Re: Agenda-Global Warehouse Remodel – 1715 5th St. NW
Erosion and Sediment Control Plan
Engineer's Stamp Date 8/18/2021 (H14E100A)

Based upon the information provided in your submittal received on 8/20/2021, the above-referenced plan is approved for Grading and Demolition only. Prior to approval of the ESC Plan for Building Permit and Work Order, the following areas of concern must be resolved.

TEMPORARY EROSION AND SEDIMENT CONTROL PLAN

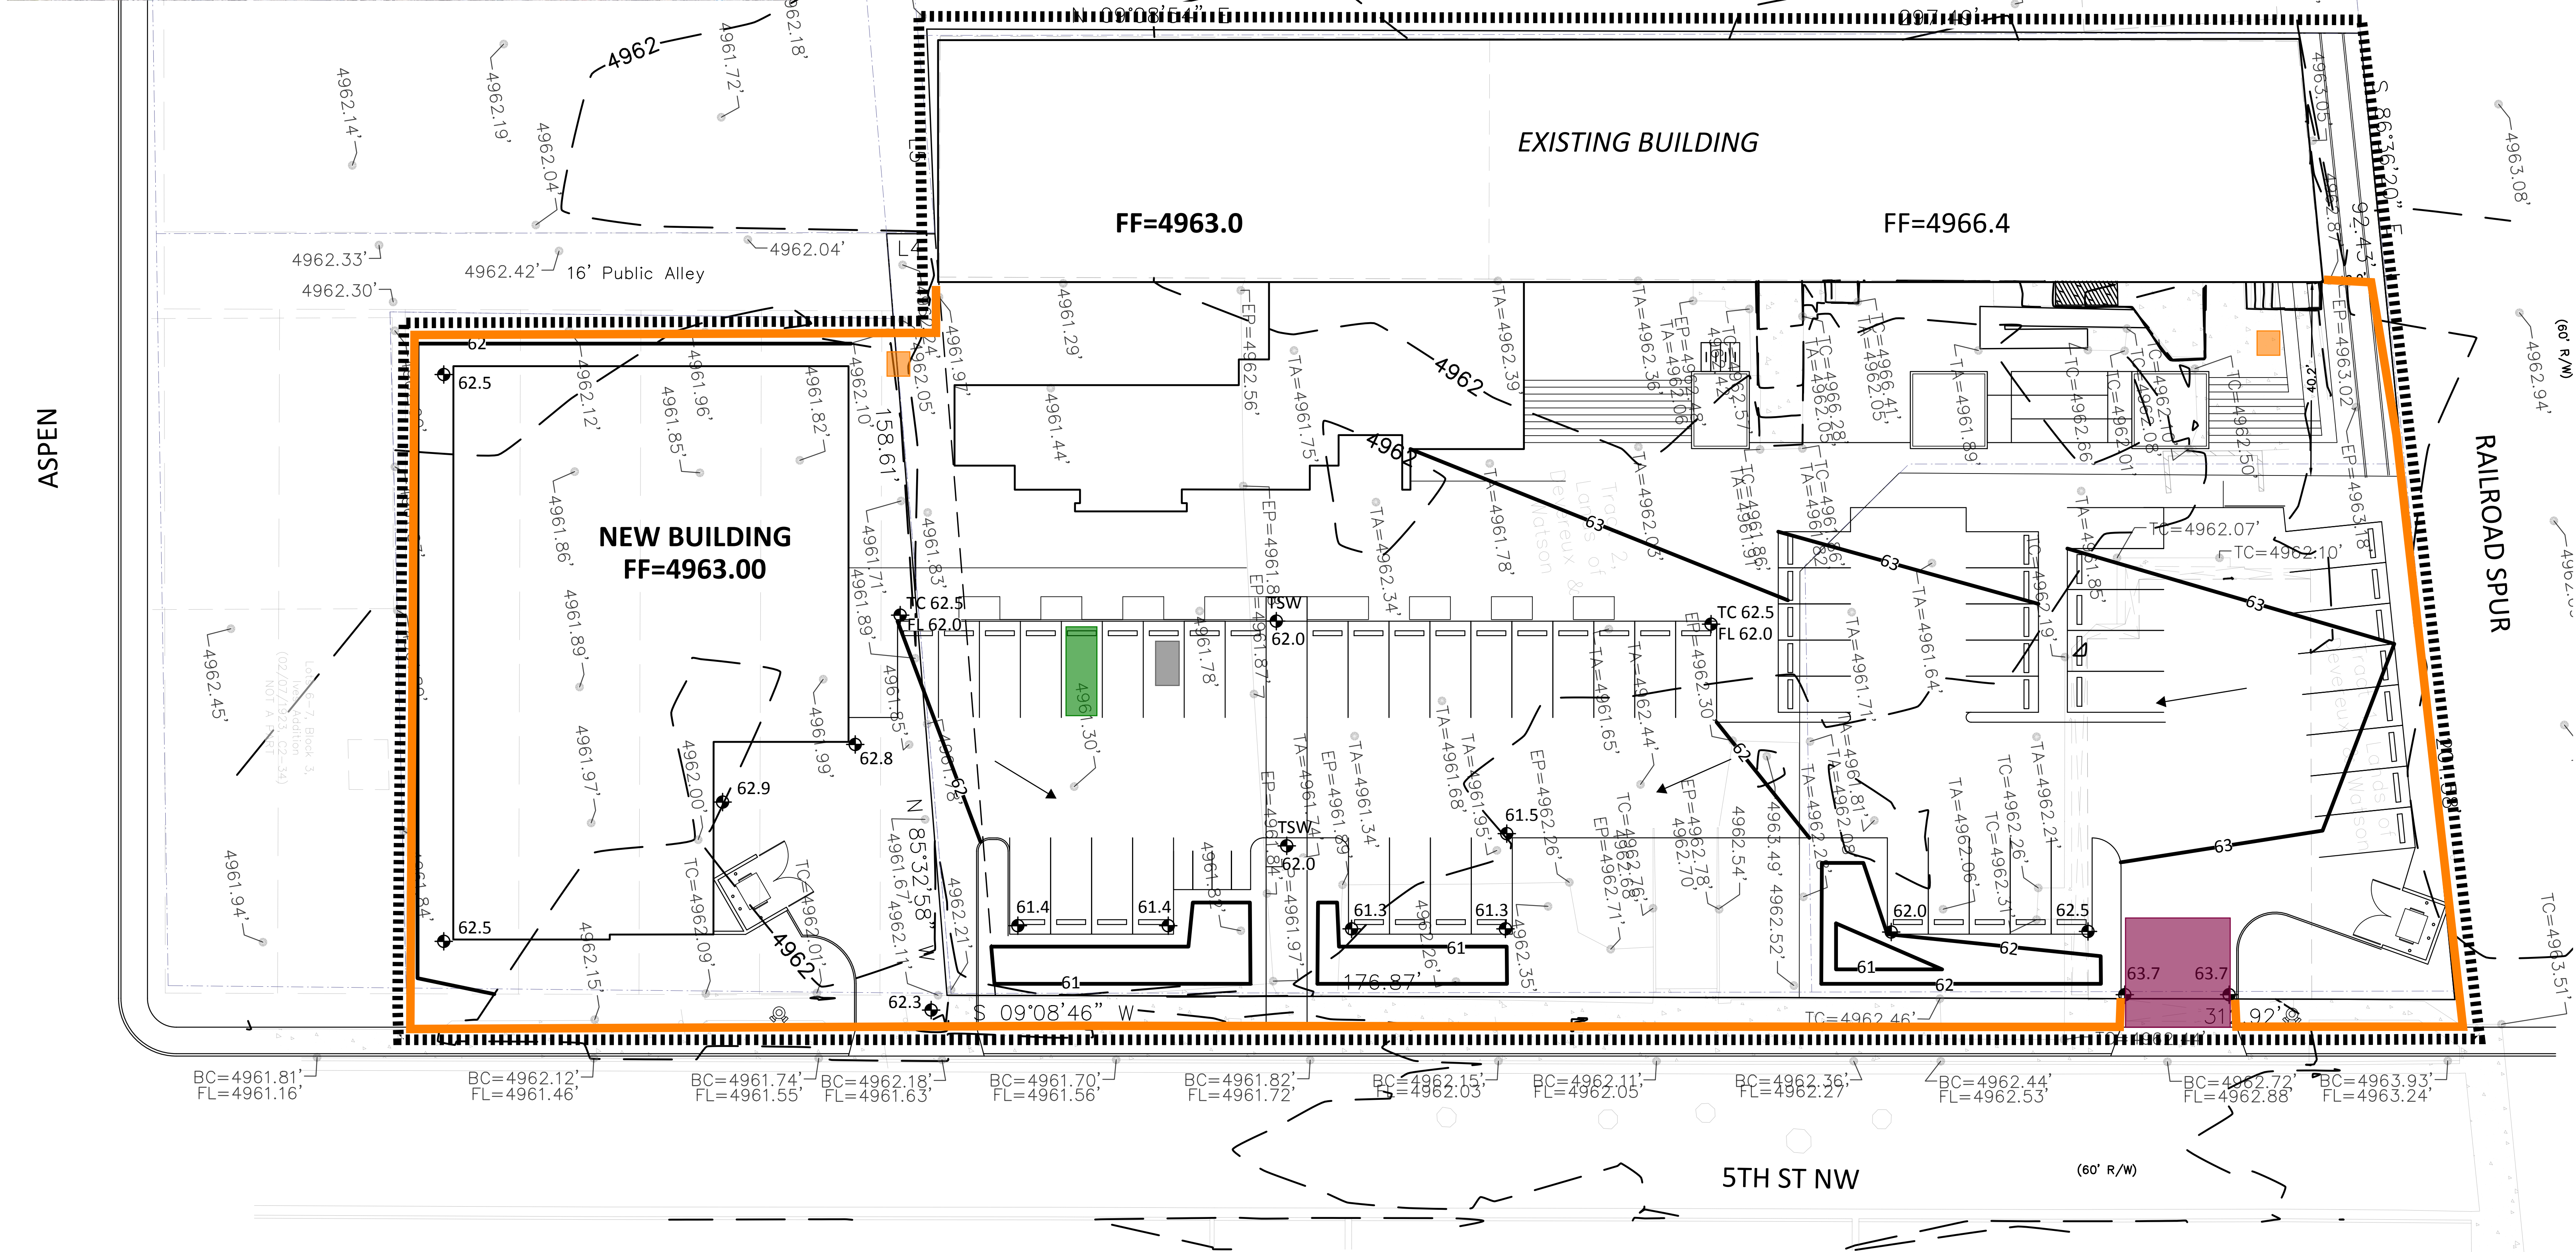
1. The property owner's NOI is required prior to beginning any construction activities. The NOI must be in the SWPPP and available onsite (CGP7.3).
2. The ESC Plan cannot be approved until after the G&D Plan is approved by Hydrology. The existing and proposed grades must be shown on the plan, and they must agree with the Grading Plan approved by Hydrology (CGP7.2.4.b.ii).

3. I can't tell the difference between building, sidewalk, asphalt, and dirt on the ESC Plan. These structures must be clearly identified in the SWPPP per CGP 7.2.4.b.v. The same information is required in the ESC Application. You may include a copy of the Site Plan in both the SWPPP and in the ESC Application to address this requirement.
